CITY OF PORTLAND, MAINE
 DEVELOPMENT REVIEW APPLICATION
 PLANNING DEPARTMENT PROCESSING FORM
 DRC Copy

2005-0194
 Application I. D. Number
 8/29/2005
 Application Date
 single Family Home lot#7
 Project Name/Description

RE: Lot #11 Ballpark Drive - #371-A-041- R-2 Zone - application #05-0461

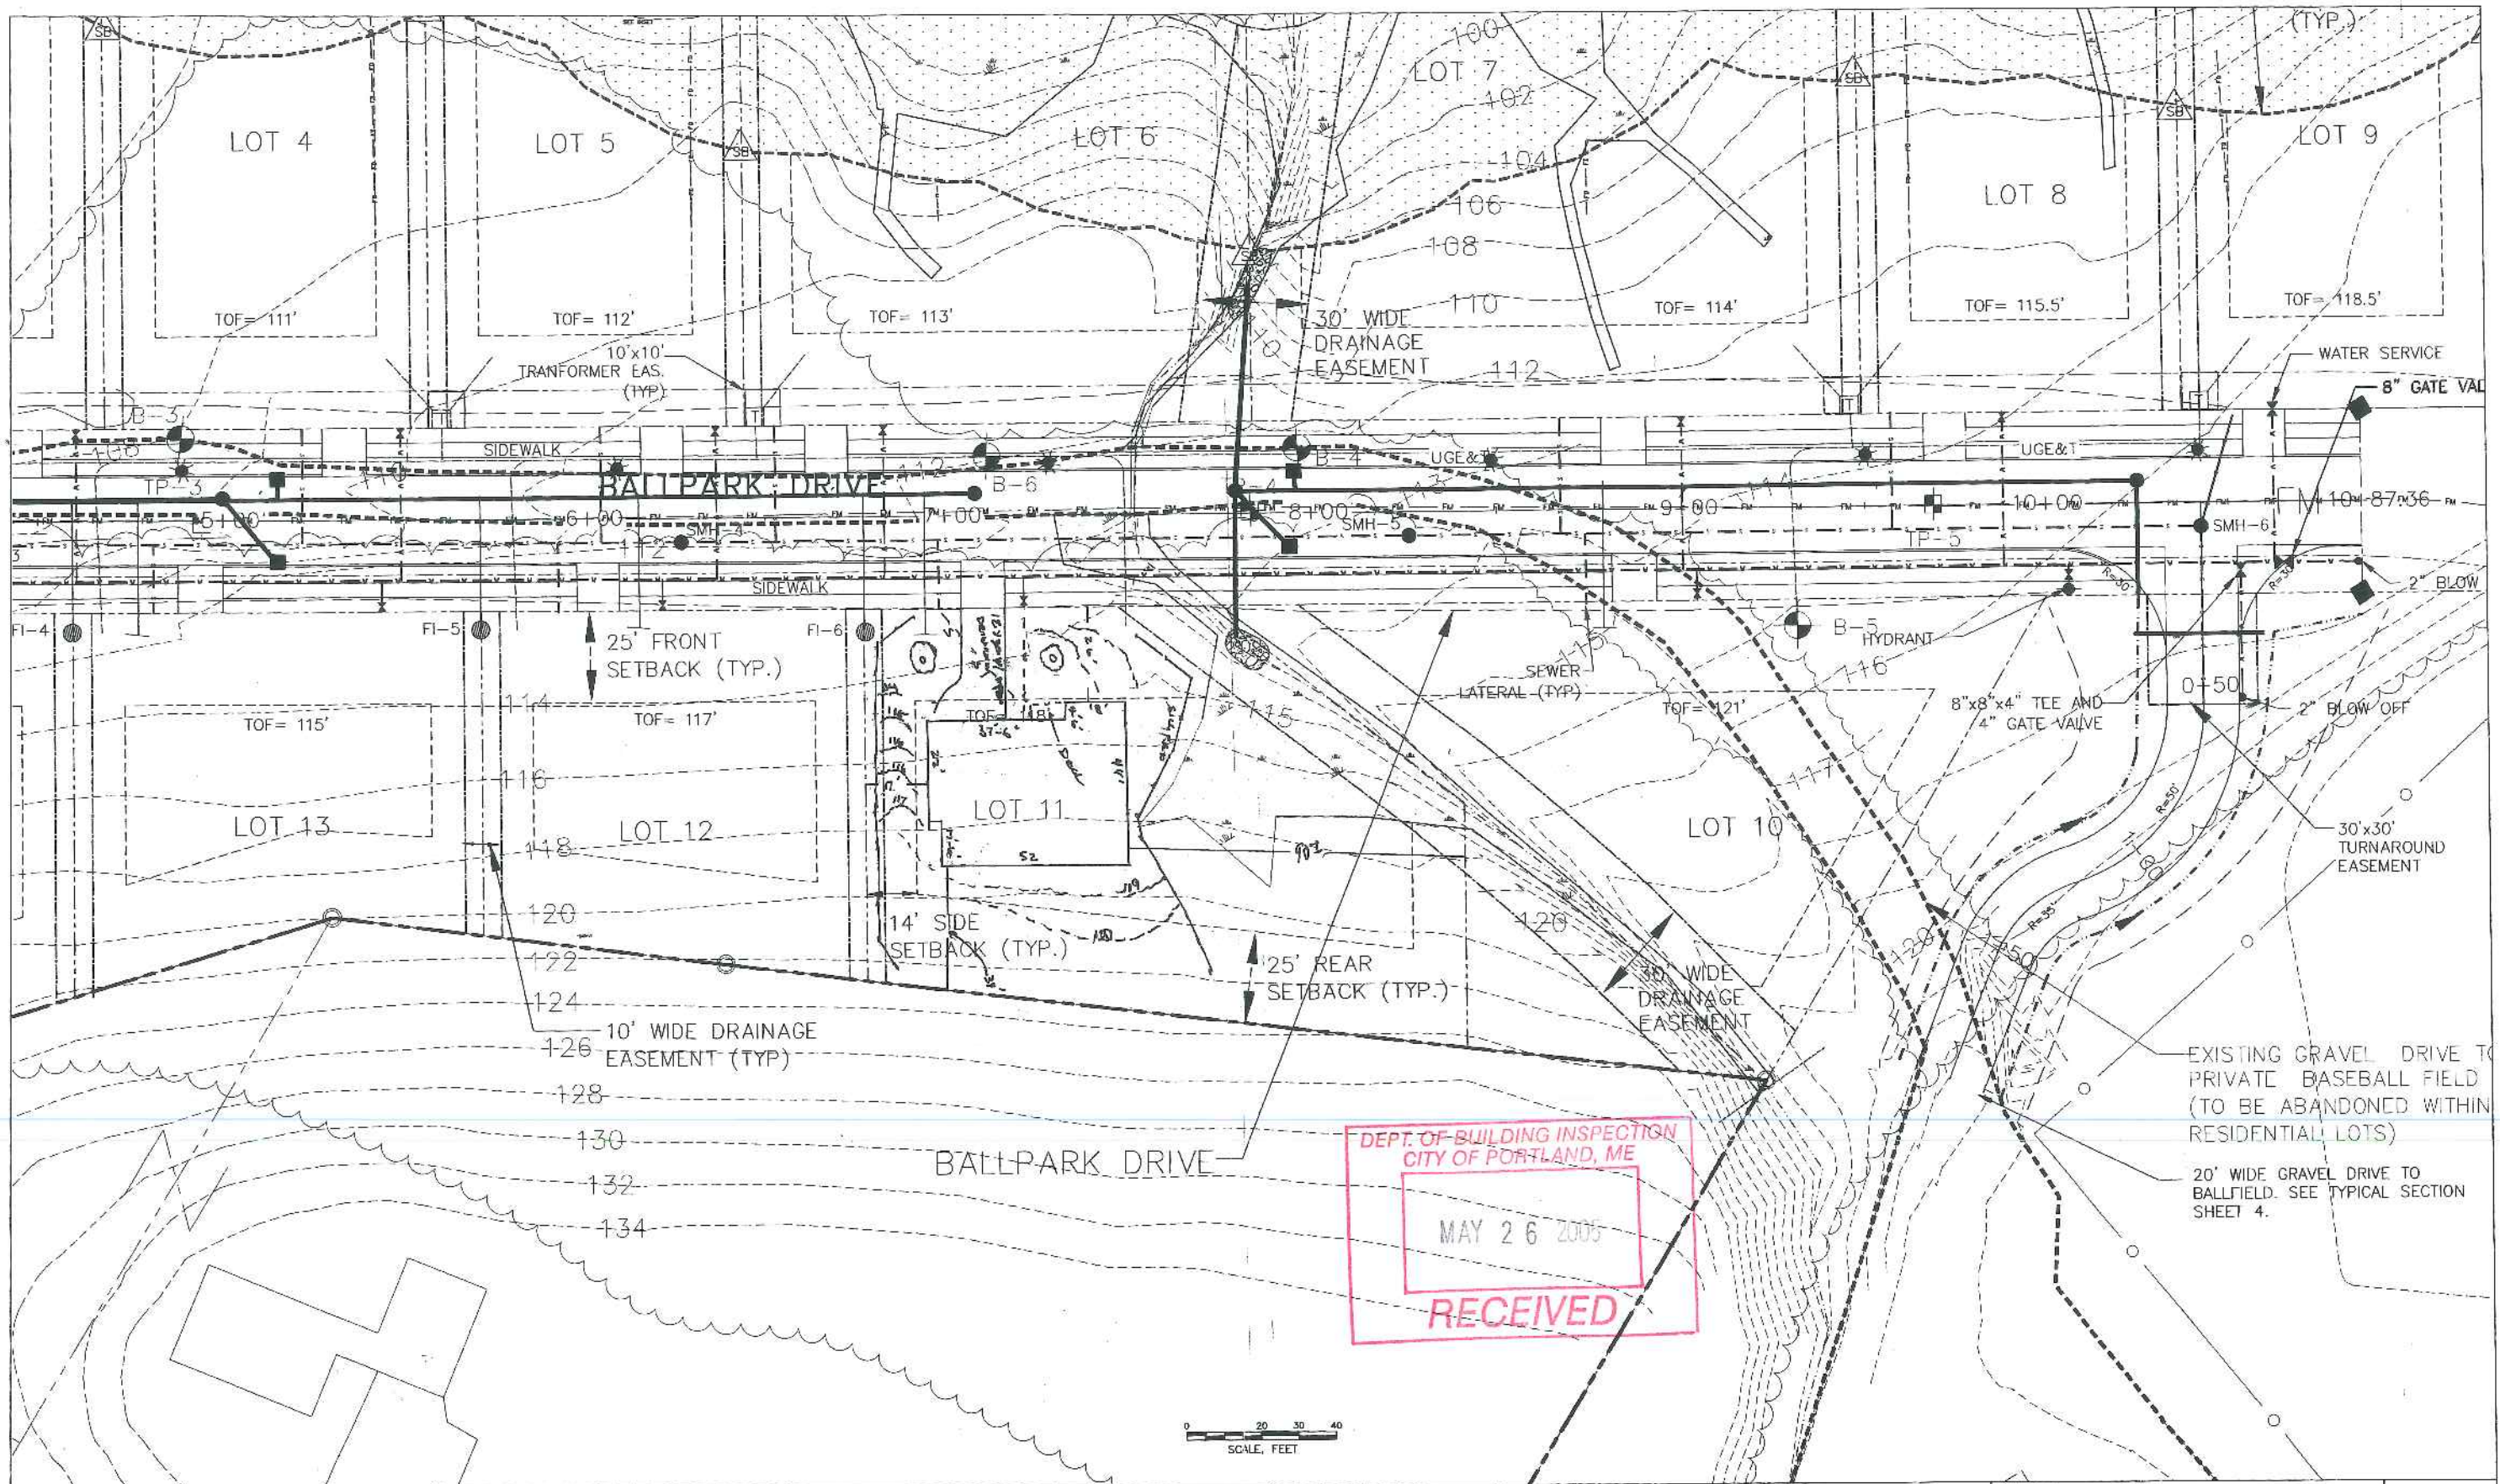
You have not submitted a scaled site plan showing the proposed, dimensioned structure. Your currently submitted site plan does not match your submitted building construction plans. Your site plan must show all projections, including, but not limited to, decks, stairs, chimneys, and bay windows.

Attached is a 30-scale, legible, readable, plan that shows the following information needed to approve a single family application in an approved subdivision:

house, existing/proposed topography, utilities, driveway, street trees, buffer zone area, finish floor elevation, etc., setbacks, erosion control... etc.
